**Re: Arrive Hotel**  
**717 Central Ave NW**  
**Traffic Circulation Layout**  
Architect's Stamp **DATE NOT PROVIDED** (K14-D022)

Based upon the information provided in your submittal 06-12-2020, the above referenced plan cannot be approved for Building Permit until the following comments are addressed:

1 BASEMENT: TRAFFIC CONTROL LAYOUT
SCALE: 1"=10'

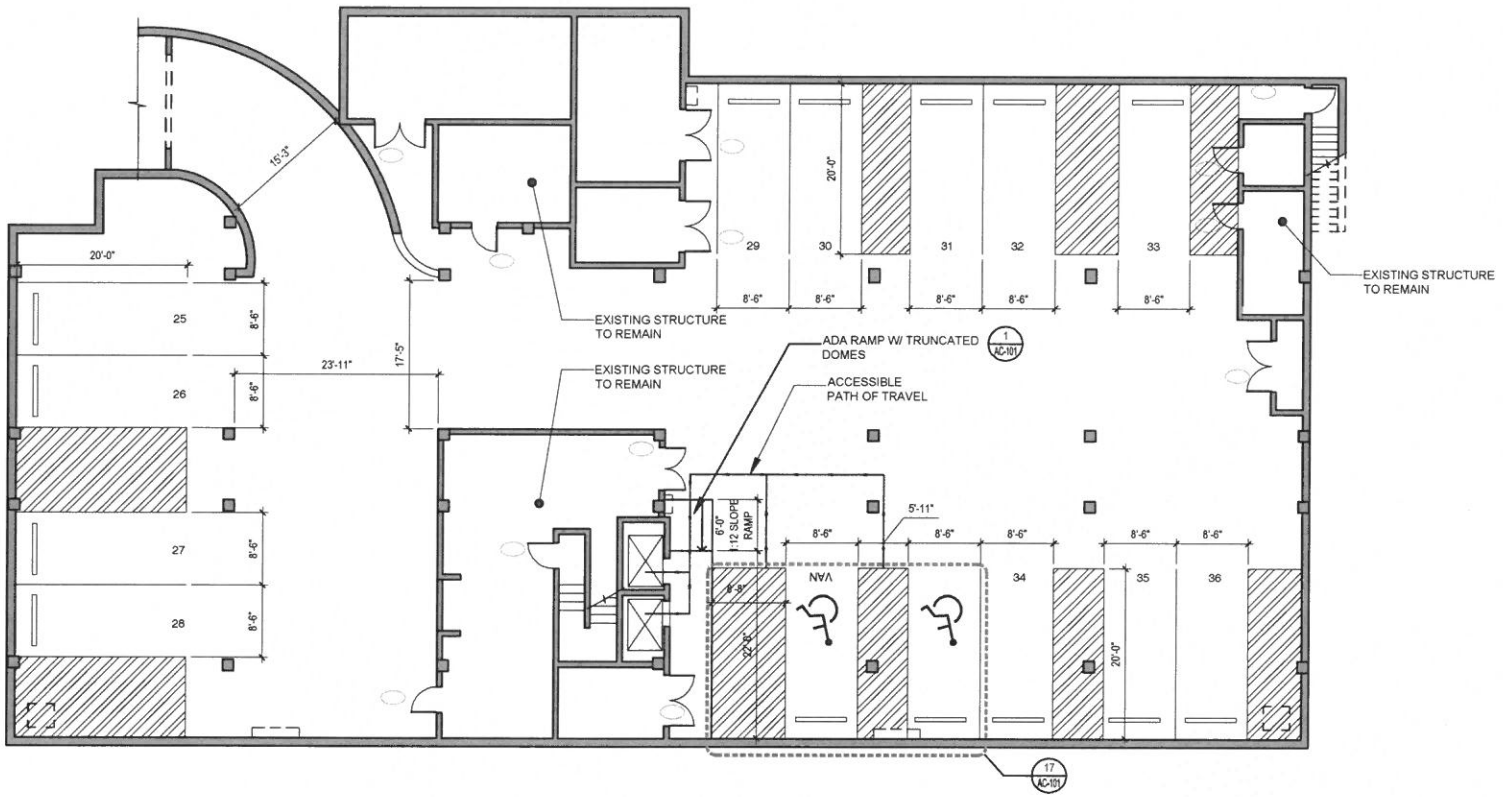
3. The dimension for 60 degree angle parking are as follows: stall length=22.9ft, stall width 9.8ft, stall depth=19.8ft (adjust proposed stalls to these dimensions). Have you adjusted these dimensions to the parking stalls? The 22.9 ft stall length is to the centerline of stall.

4. Per the IDO, a **6 ft. wide ADA accessible pedestrian pathway** is required from the public sidewalk to the building entrances. Please **clearly show** this pathway and provide details. The pathway will need to be striped across drive aisle in front of building (Porte Cochere).

4 DO NOT ENTER SIGN DETAIL

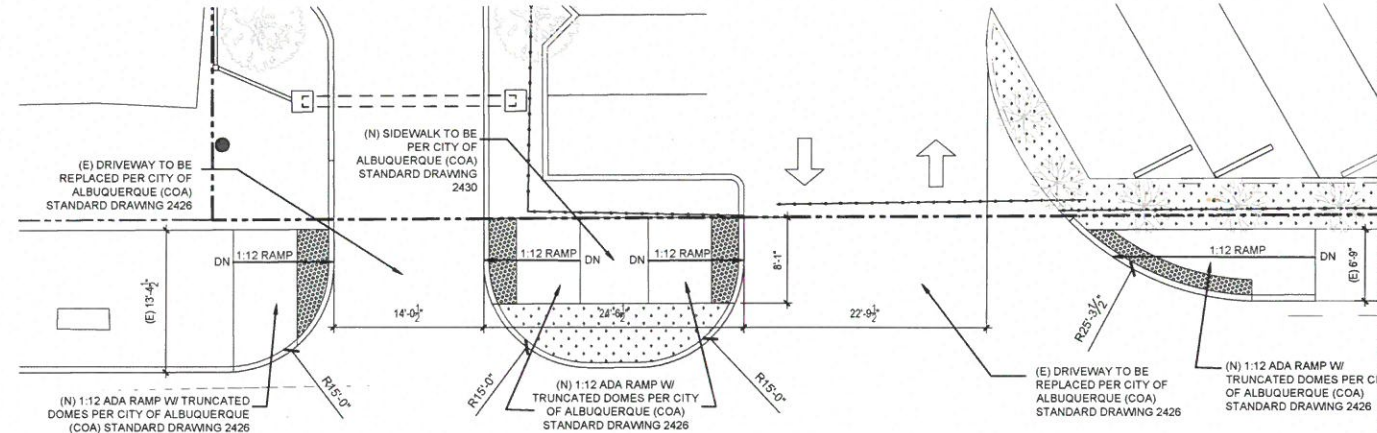
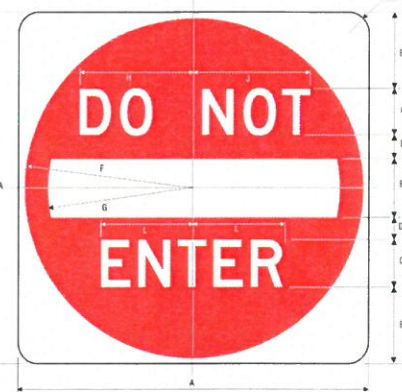
5. All one-way drives and at end of **DRIVE AISLE** shall have "One Way" and "Do Not Enter" signage (**separate signage for each**) and **pavement markings**. Please show detail and location of posted signs and striping. They signage and pavement markings will need to be located on private property. On your detail sheet 2/AC-101, you show a combined signage of "One Way" and "Do Not Enter", how was this signage determined and is it a regulatory sign from MUTCD? Was it obtained from the MUTCD guide? If not, then you will need to provide signage from MUTCD guide.
